Rezoning Transportation Analysis

Petition Number: 2023-039

From: Jake Carpenter, PE

Date	Description
7-26-23	First Review (IW)
11-27-23	Second Review (DR)
2-21-24	Third Review (NK)
3-20-24	Fourth Review (NK)

SECTION C - PUBLIC STREET (NETWORK)
2+ AVENUE, BUFFERED/SEPARATED BIKE LANES
SCALE: 1/4\"/>

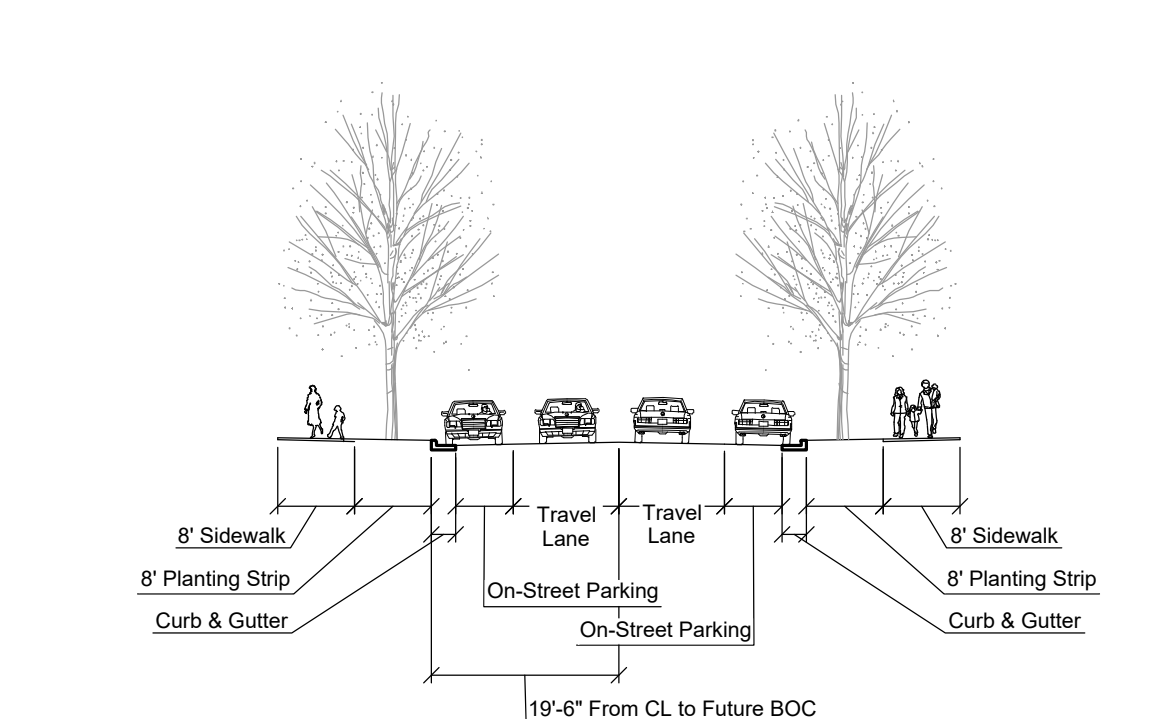
~~**Clarifying comment 11.27.23:** ROW dedication for Old Providence should be 43' based on the 8' sidewalk on Old Providence Road instead of the 6' sidewalk dimension shown on Section C.~~

~~New Comment 11.27.23:~~ Section C public street network sidewalk width does not match the conditional note. Revise Section C to have an 8' sidewalk like the conditional notes for the Old Providence Road section.

- 8. The proposed dwelling units exceeds 12 per acre. Per Chapter 20 Subdivision ordinance, revise site plan and conditional note(s) to commit to construct an 8-foot planting strip, and 8-foot sidewalk along Old Providence Road. The wider sidewalk also meets the Charlotte WALKS Policy.

RZ2-00

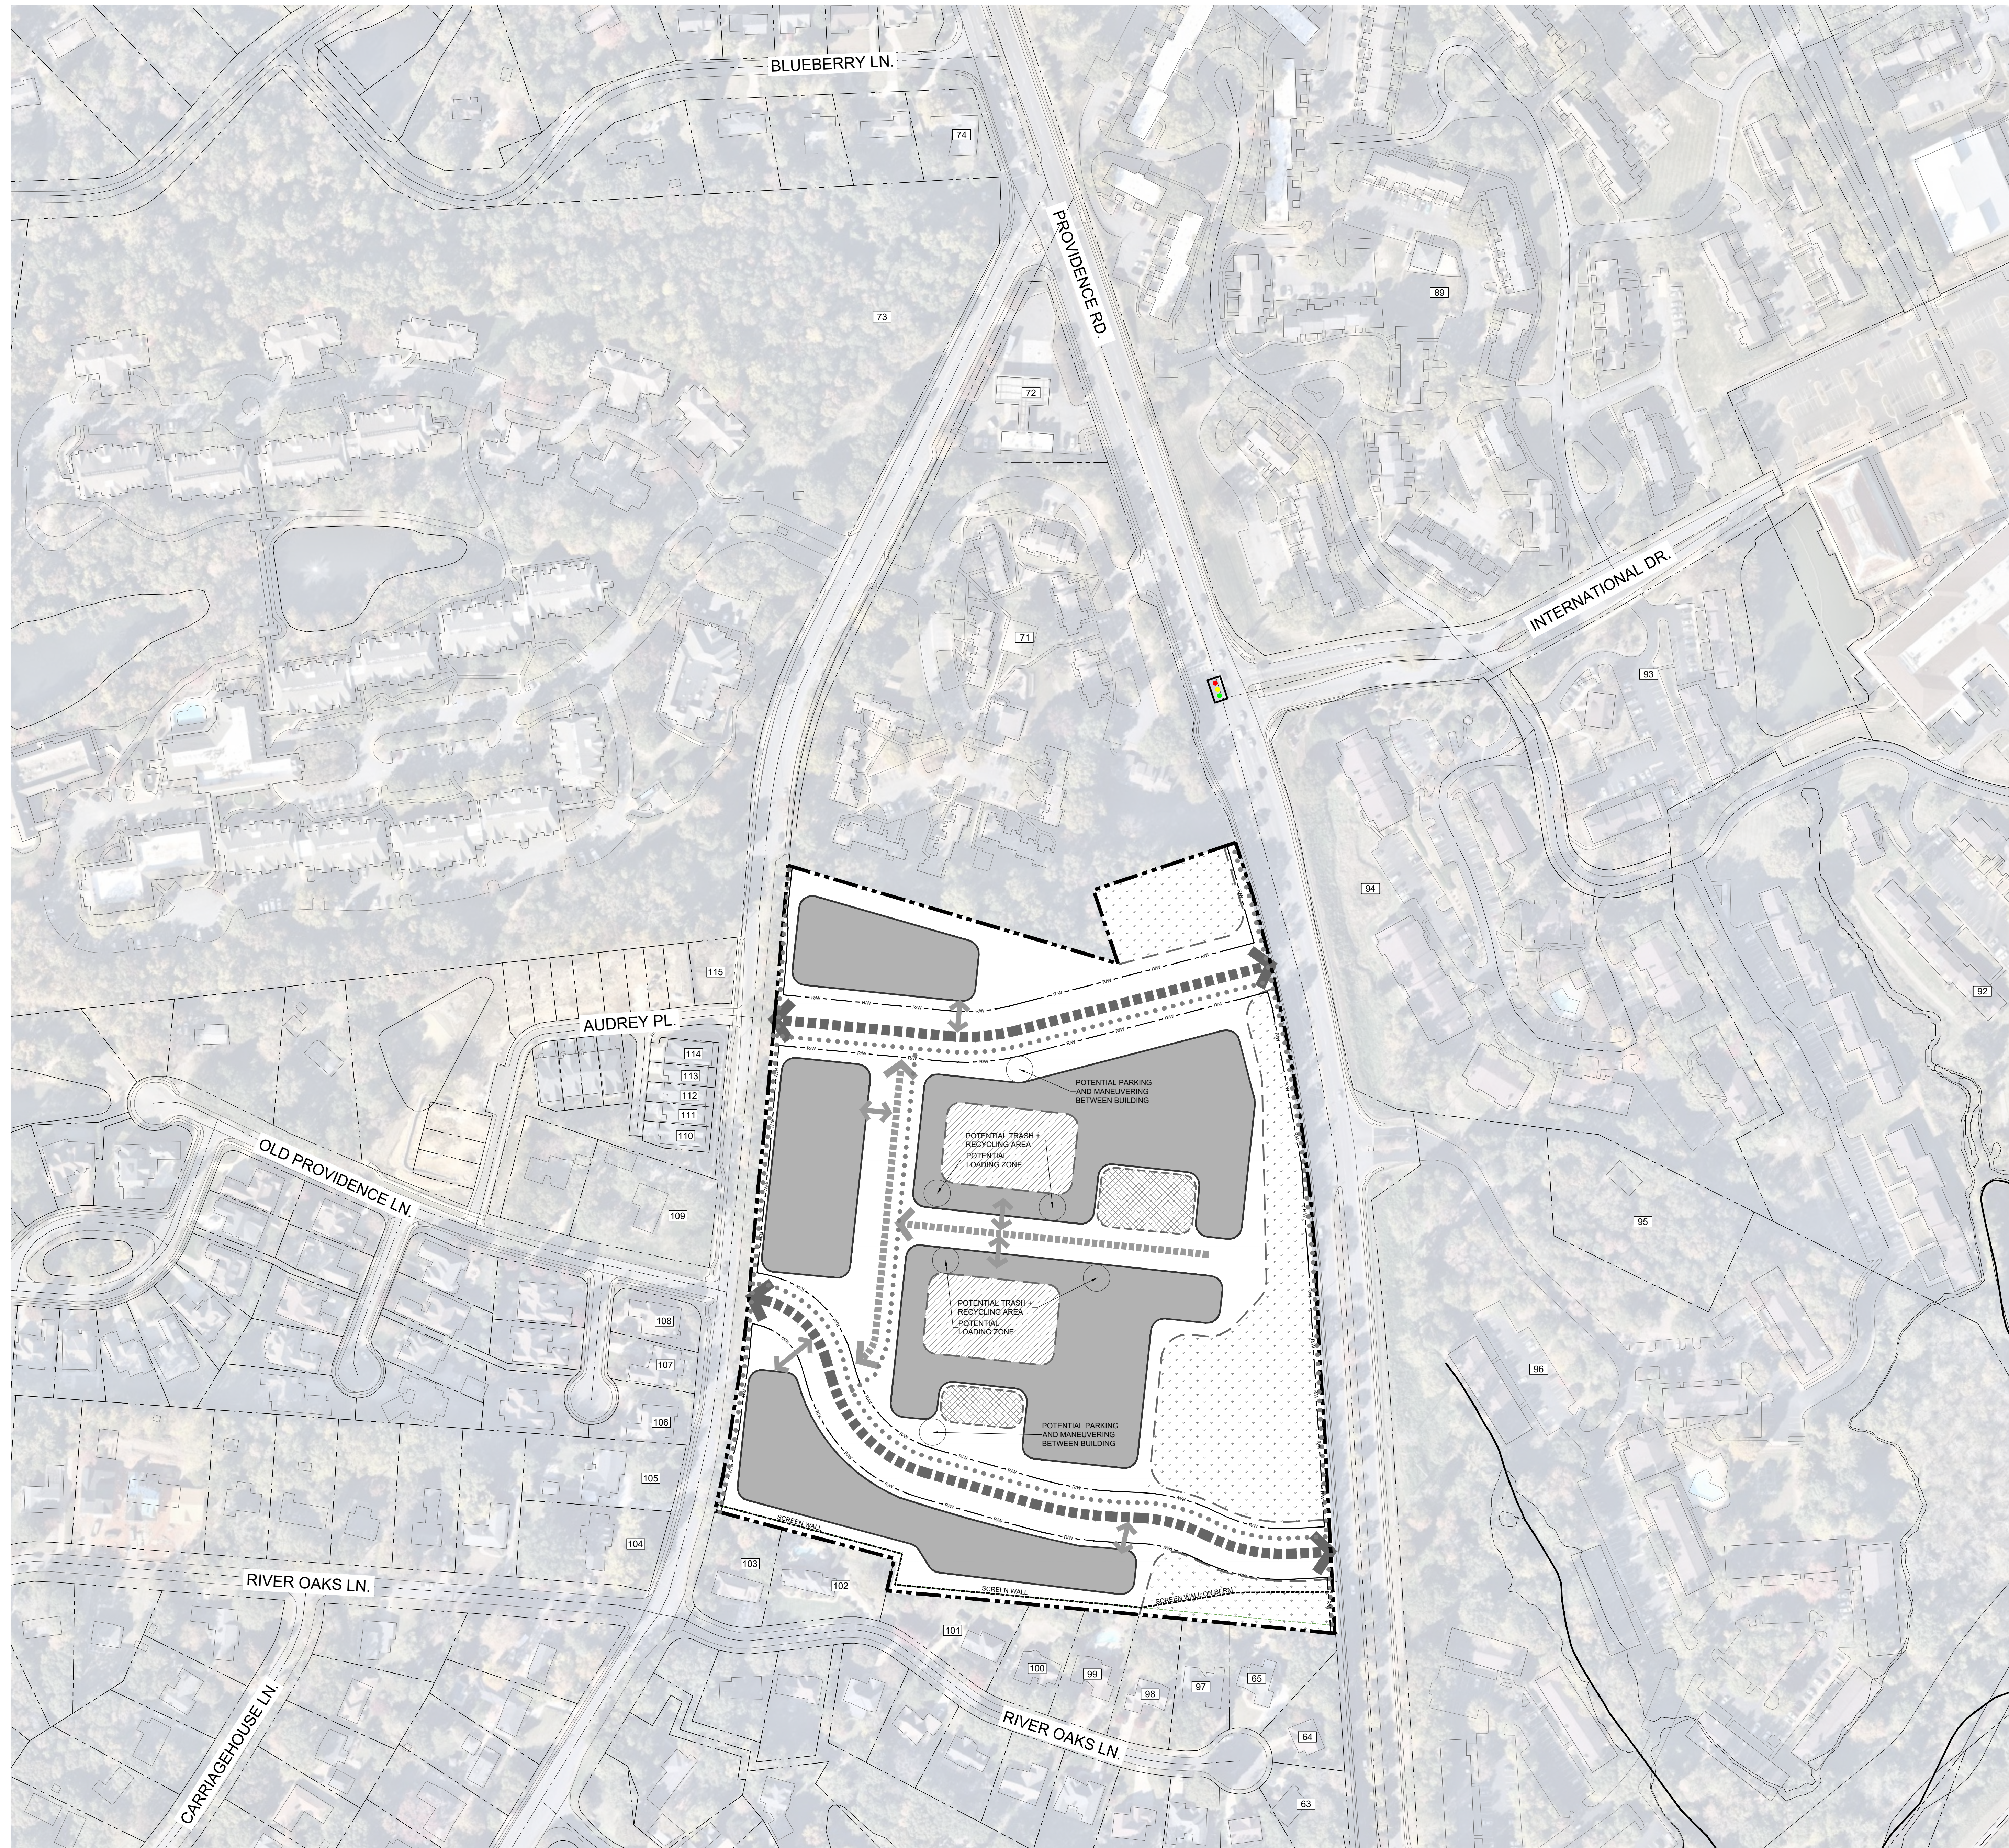
16. **New Comment 2.21.24:** Fix alignment at intersection circled below and ensure that there is at least 50' of separation between horizontal curves.

17. **New Comment 2.21.24:** Ensure that any proposed access points are at least 75' from unsignalized intersections.
